23A Epping Rd
North Ryde, NSW 2113
Ph 9887 2703
Email wilby11@bigpond.com
27 July 2015

**RE: S96 Modification Application SSD_5093 - M2 Site, North Ryde Station
Urban Activation Precinct.**

FIGURE 2 – PLAN OF PROPOSED GAS MAIN RELOCATION (REFERENCE: C-0-9-20)

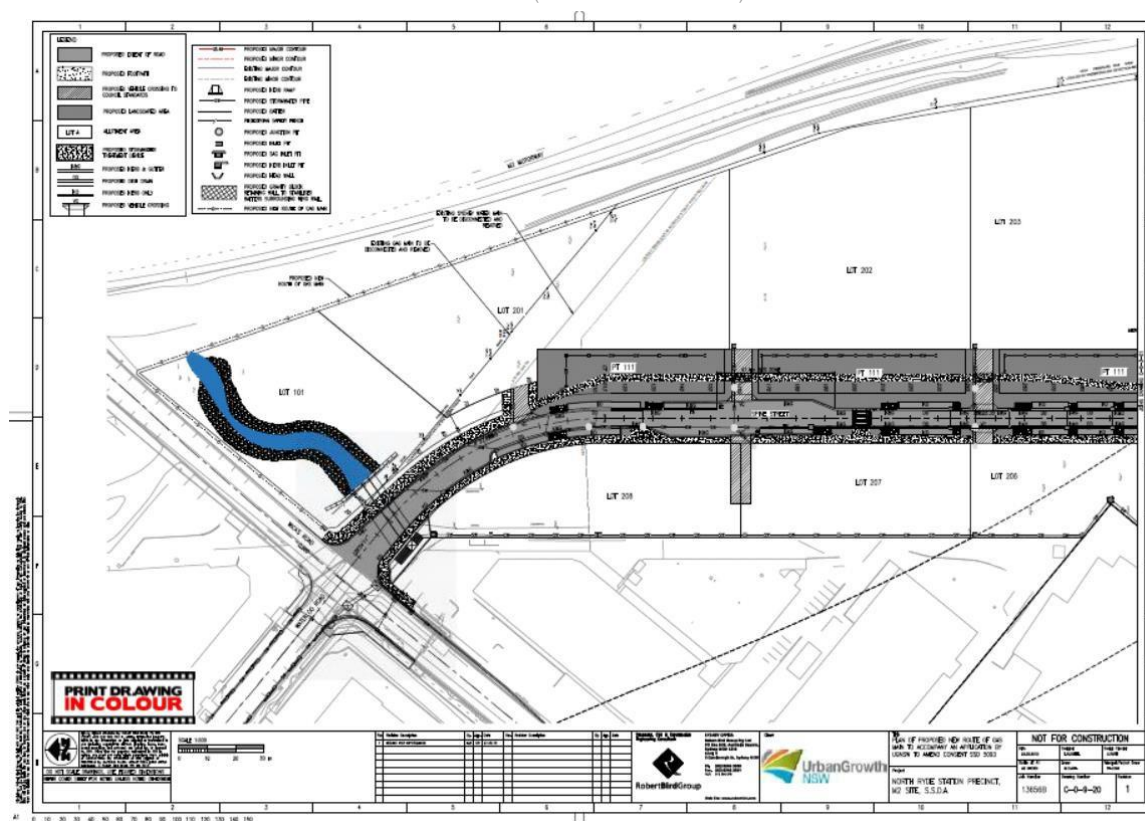
The proposal *may* inflict lesser disturbance on the bushland site, but we are unable to locate any clear and detailed illustration of the precise route. (Where does it appear on the ecological report maps? Where would it run in conjunction with the M2 tollway culvert? How would the new line be configured and remediated to provide ecological corridor connectivity? How will the new line fit into the existing network?)
